Subject: FW: Planning LU/324/18/PL Nelson Hotel

Subject: Re: Planning LU/324/18/PL

SOUTH TERRACE / ALLEY ELEVATION (SOUTH EAST)

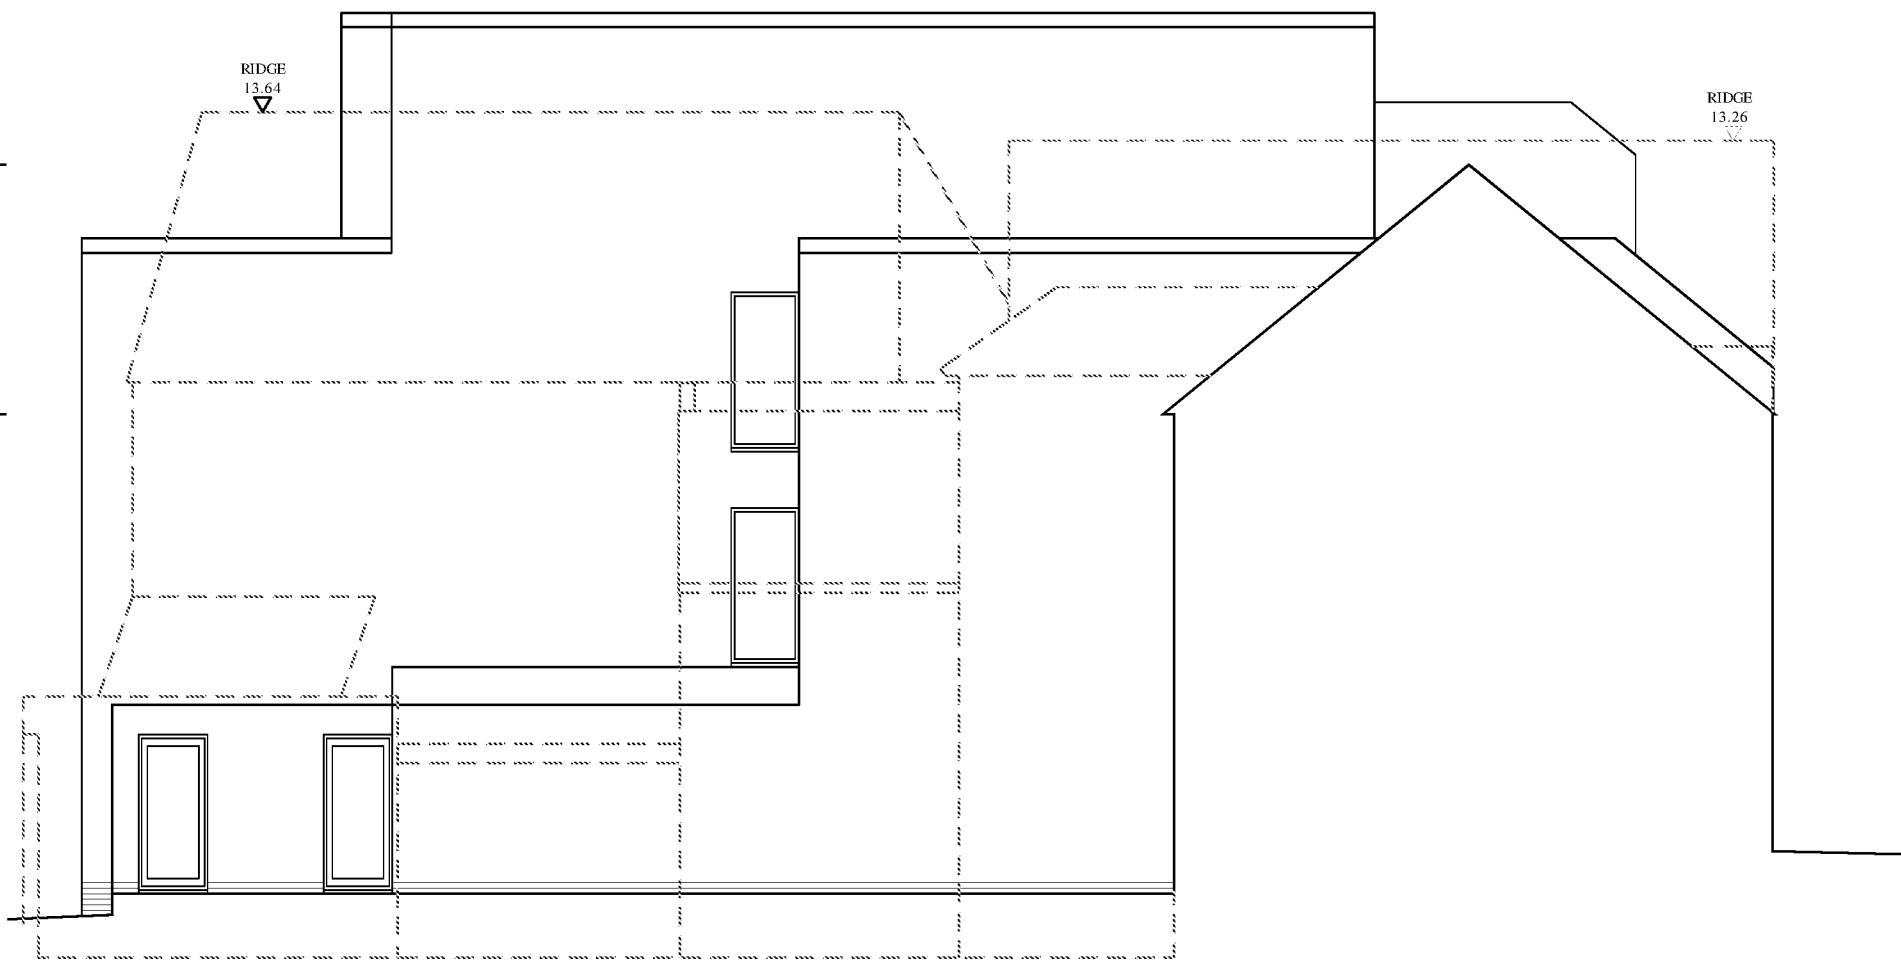
Whilst I agree with you about the visual assessment of the South section of the Pier Road and the view of the rear of South Terrace I do not agree with your assessment of the visual aspect of South Terrace frontage. It retains character & a predominant building material.

Therefore I believe that an amendment to the application to amend that Southern frontage to better relate to this would improve the application.
